Application No: 10/01780/HYBRID	Ward: Caversfield	Date Valid: 23/12/2010
---	--------------------------	----------------------------------

Site Address:	Bicester Eco Town Exemplar Site Caversfield Oxfordshire
----------------------	---

Proposal: Development of Exemplar phase of NW Bicester Eco Town to secure full planning permission for 394 residential units and an energy centre (up to 400 square metres), means of access, car parking, landscape, amenity space and service infrastructure and outline permission for a nursery of up to 350 square metres (use class D2), a community centre of up to 350 square metres (sui generis), 3 retail units of up to 770 square metres (including but not exclusively a convenience store, a post office and a pharmacy (use class A1)), an Eco-Business Centre of up to 1,800 square metres (use class B1), office accommodation of up to 1,100 square metres (use class B1), an Eco-Pub of up to 190 square metres (use class A4), and a primary school site measuring up to 1.34 hectares with access and layout to be determined.

Figure 3 – Bridge 1 & 2 Design Drawings

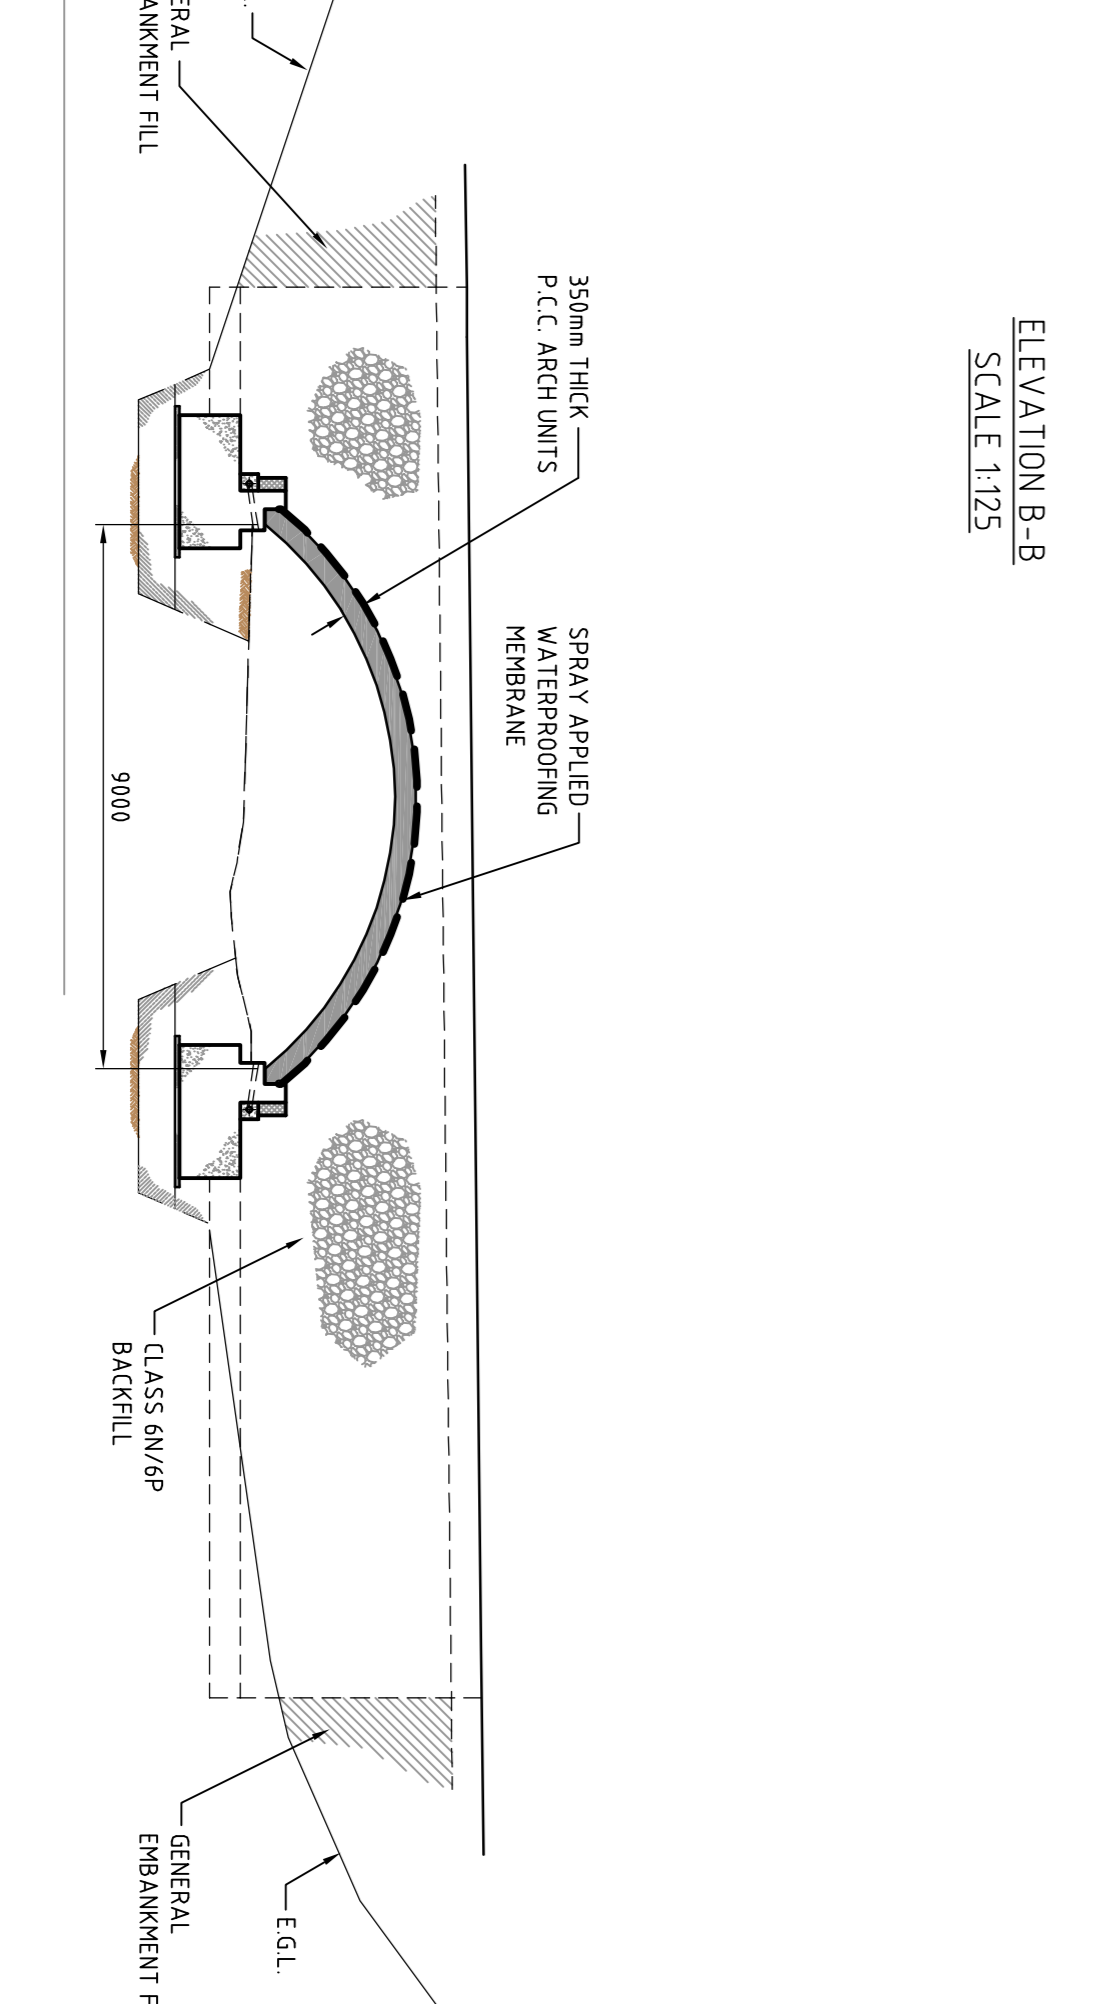
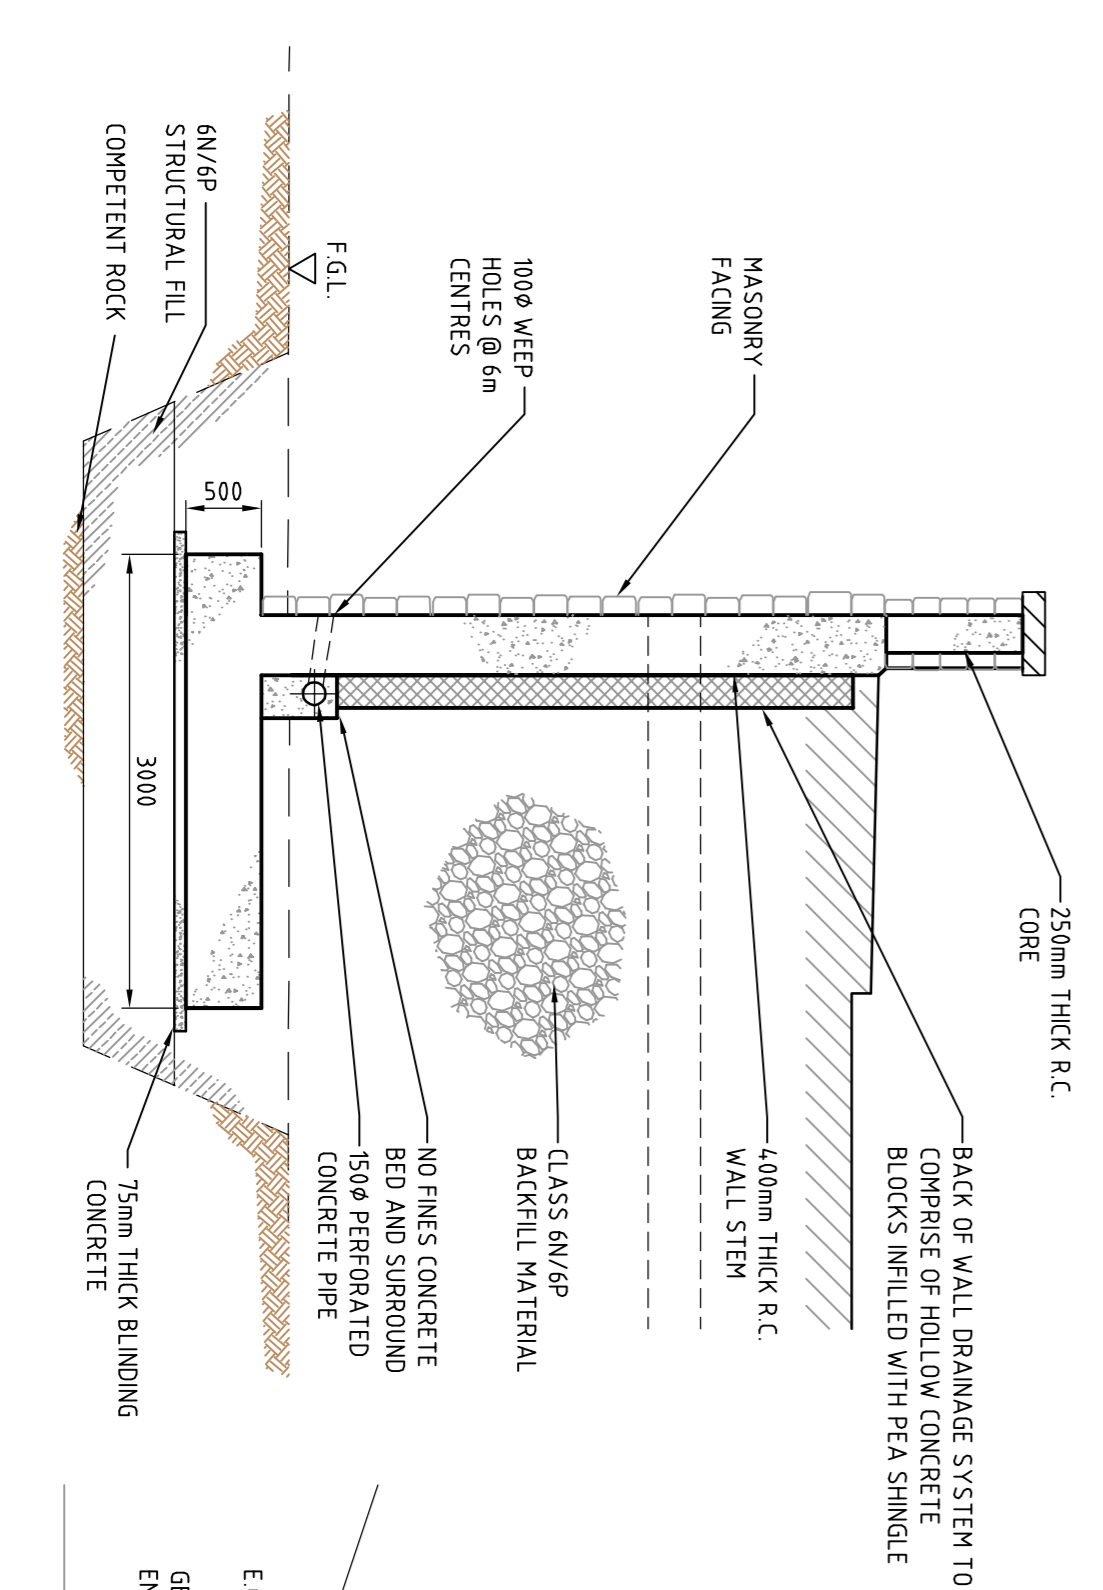
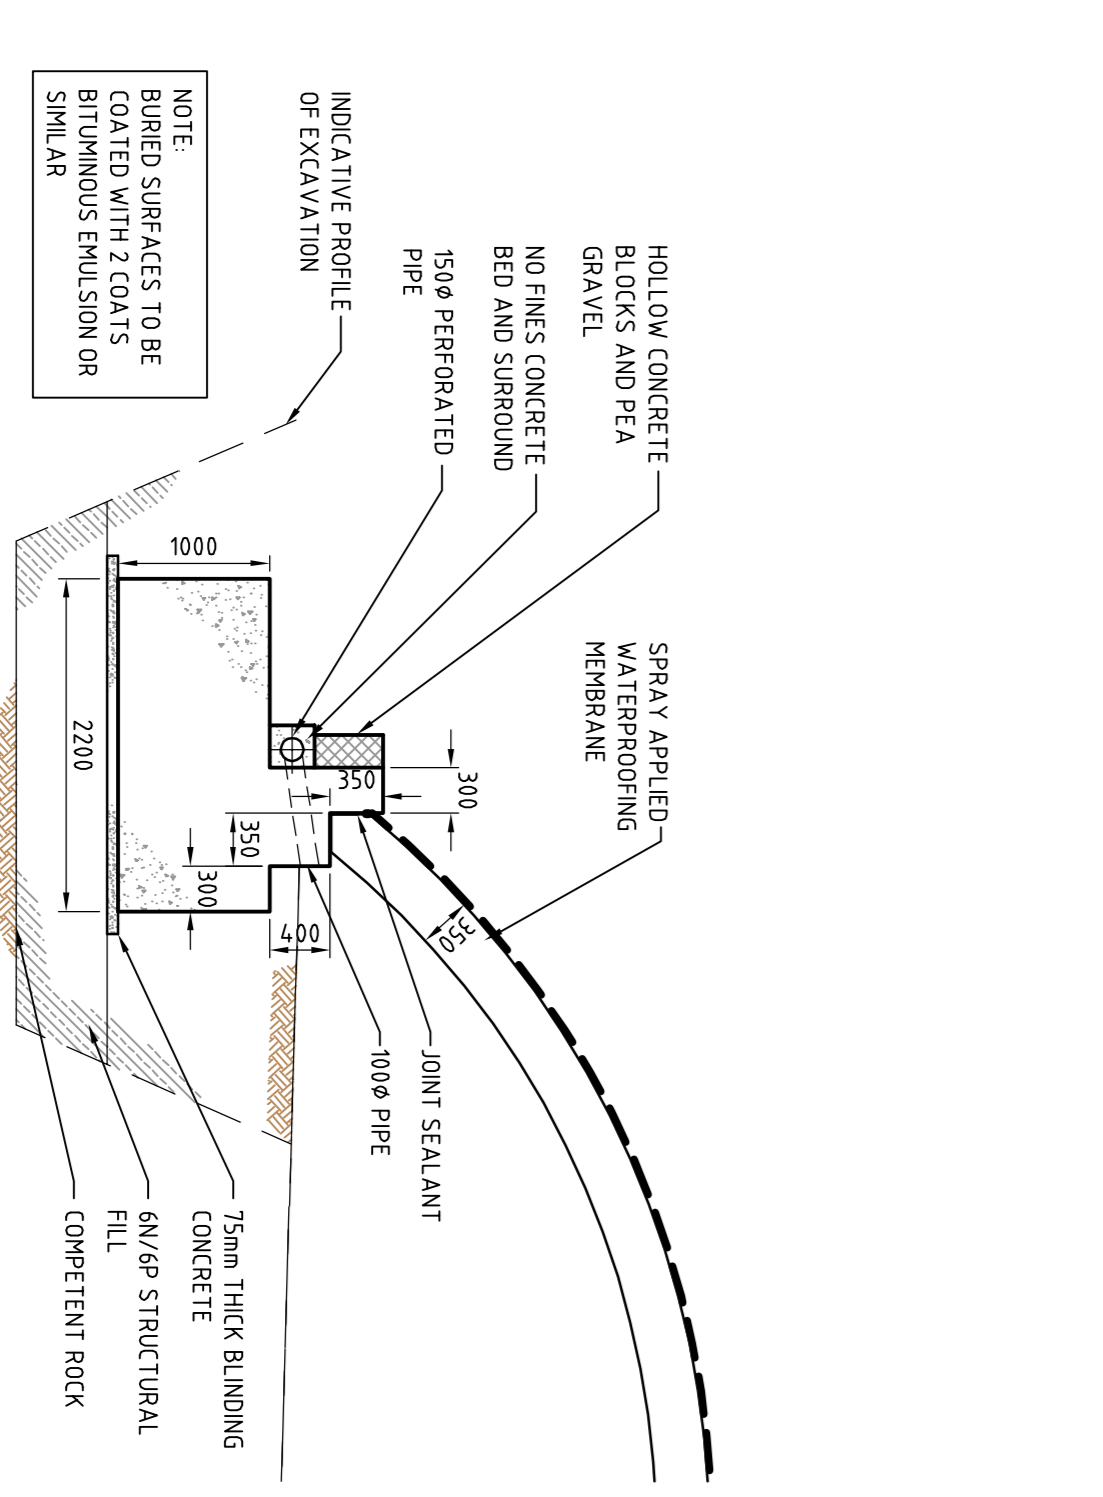
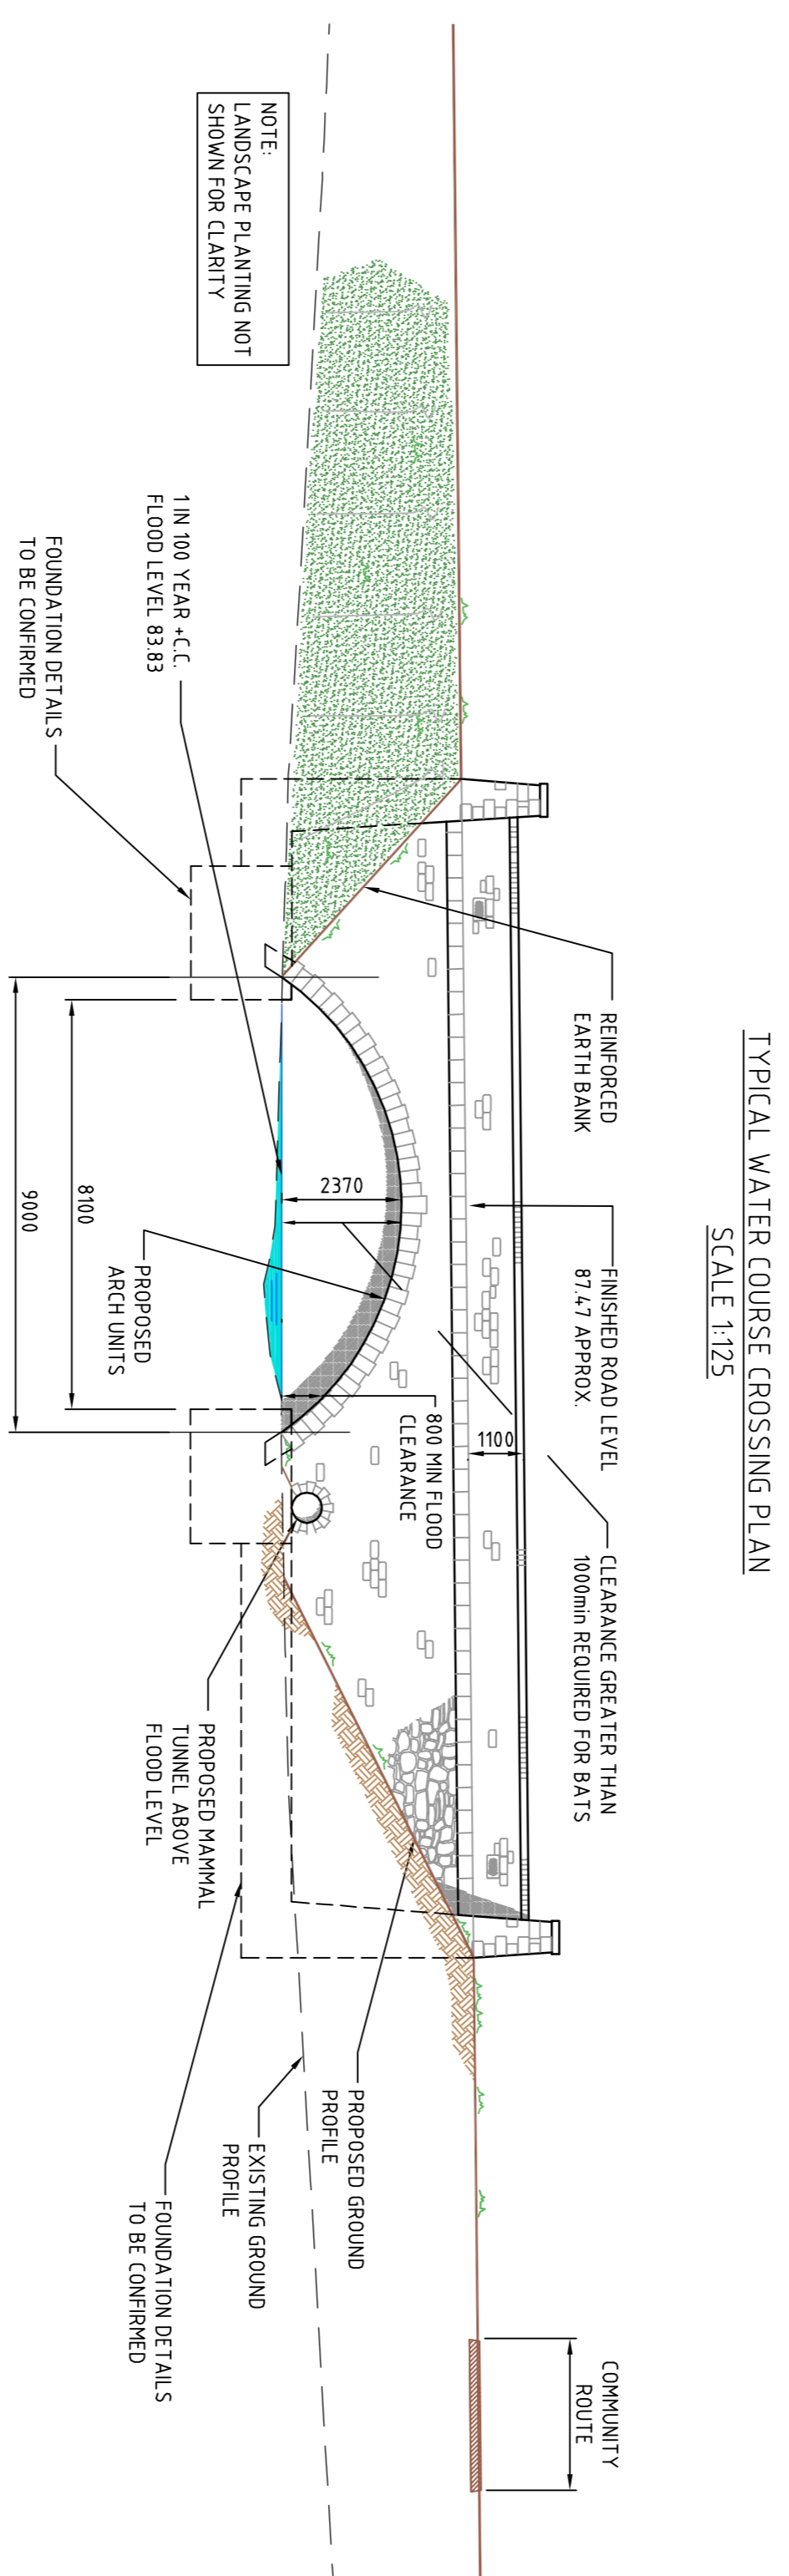
- The two bridges proposed within the site appear to be structurally sound, but the functional appearance is a missed opportunity to create an architectural statement that is exemplary in its design. Further details are required before “Approved In Principle” (AIPs) plans can be issued for their implementation.
